OXFORDSHIRE COUNTY COUNCIL'S RESPONSE TO CONSULTATION ON THE FOLLOWING DEVELOPMENT PROPOSAL

Application no: 23/00977/OUT

Proposal: Outline Planning Application (except for access) for residential development of up to 60 dwellings (Use Class C3) including a community facility, new vehicular and pedestrian access off Claydon Road, public open space and associated landscaping, earthworks, parking, engineering works and infrastructure

Location: OS Parcel 9195 North Of, Claydon Road, Cropredy

Title :
Proposed Site Access & Visibility Splays

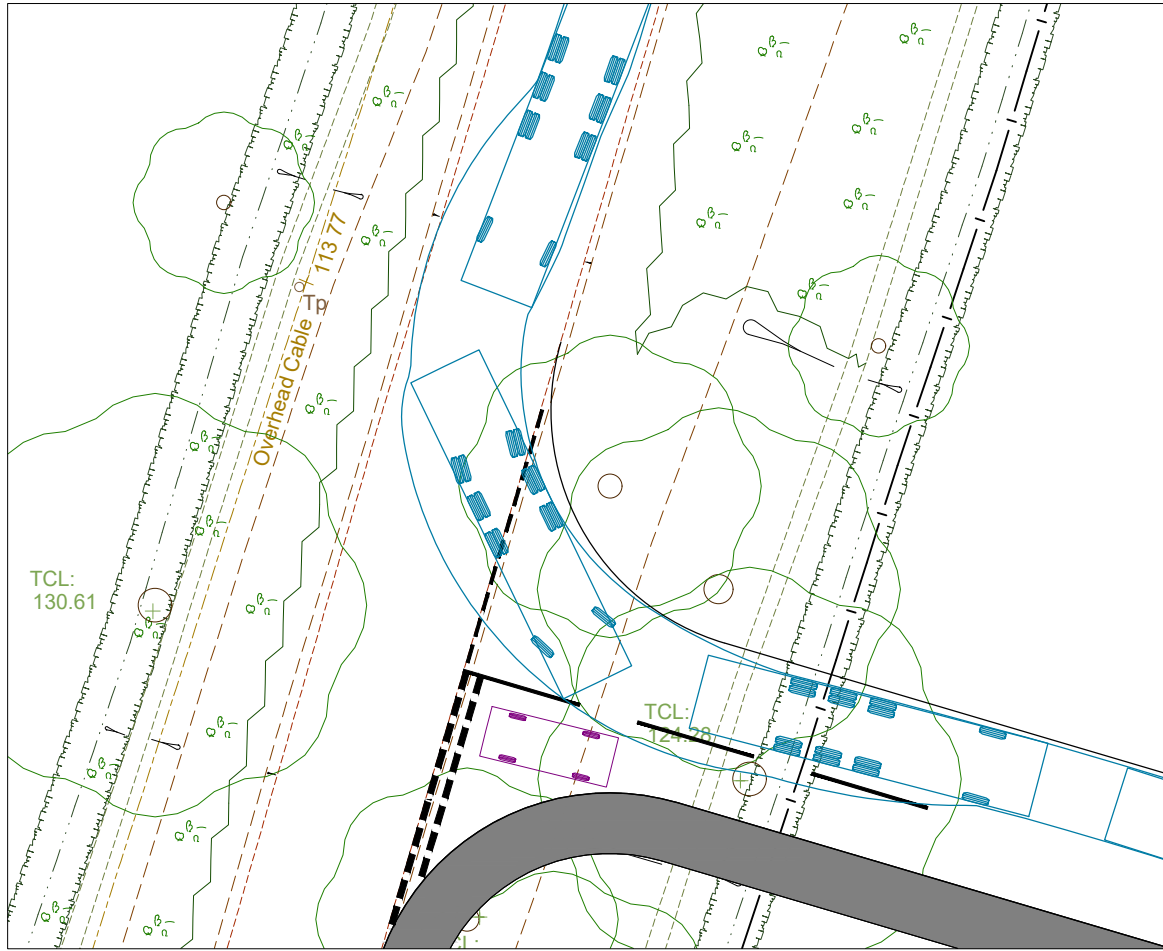
Vehicular Access- the proposed vehicular access to the site is proposed from Claydon Road via a 5.5m wide access road with 8.0m radii at the junction. An access arrangement drawing is provided at Appendix D. 4.6 It is noted that the site is some 1.5m lower than the road at the proposed access location and as such, levels within the site will be built up to ensure an appropriate gradient of 1:20 is achieved along the site access. A site access/clarendon Road junction design layout details with dimensions with better clarity for assessment would be needed to facilitate the approval of this outline application from the transport perspective.

Roads comments: -The suite of application plans does not provide much detail regarding the access with carriageway and footway widths and therefore it is not clear if what is being proposed is feasible. Without this information the LHA would recommend that this application is opposed until these dimensions and information below are provided.

If access is proposed to be 1:20, it should have flat landing spots to comply with DDA and inclusive mobility specifications

Swept Path Analysis

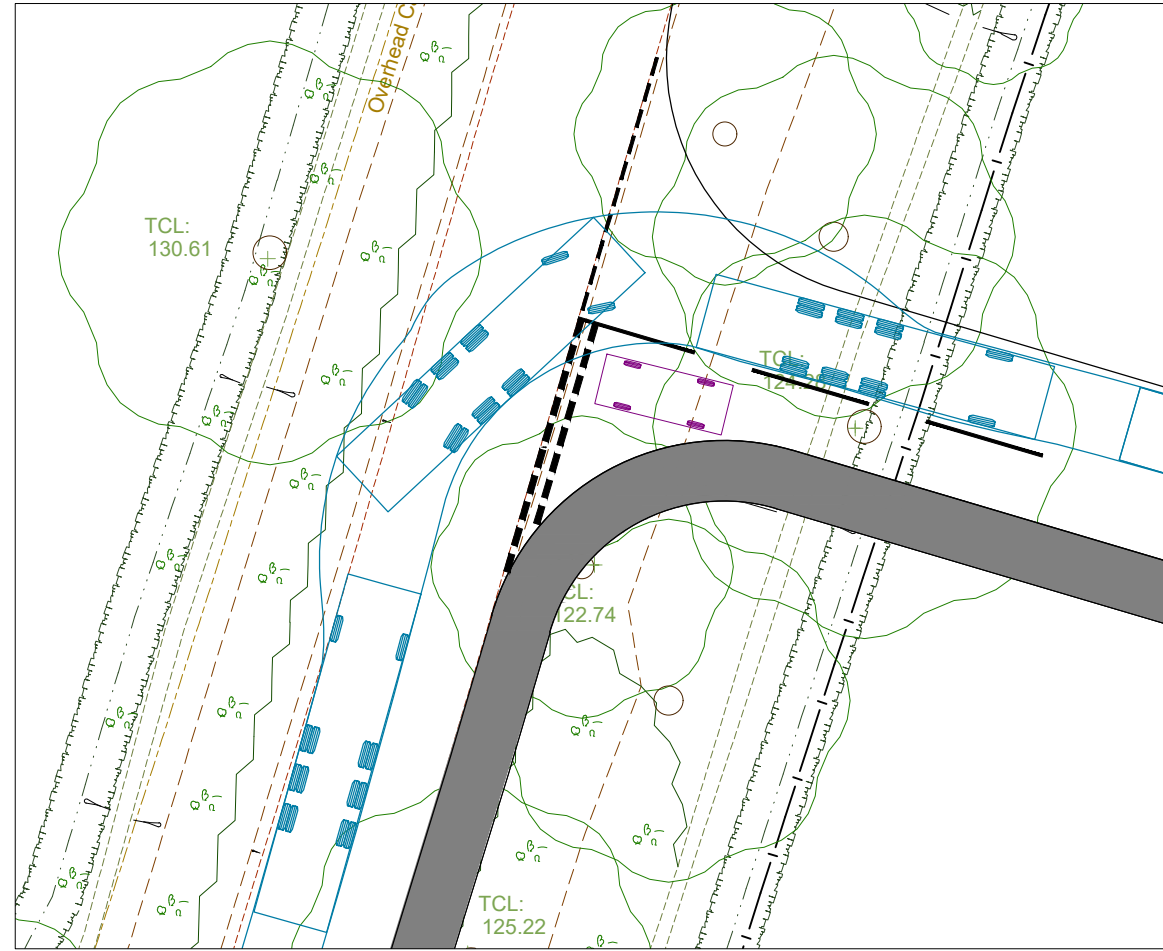
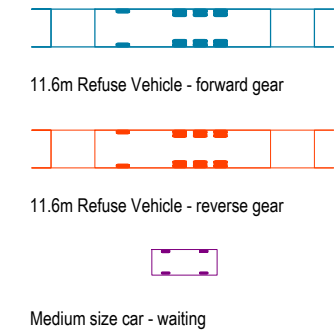
It is evident that the Vehicle tracking at the access largely covers opposite lanes on all movement which could cause collisions, this should be addressed by the Applicant.
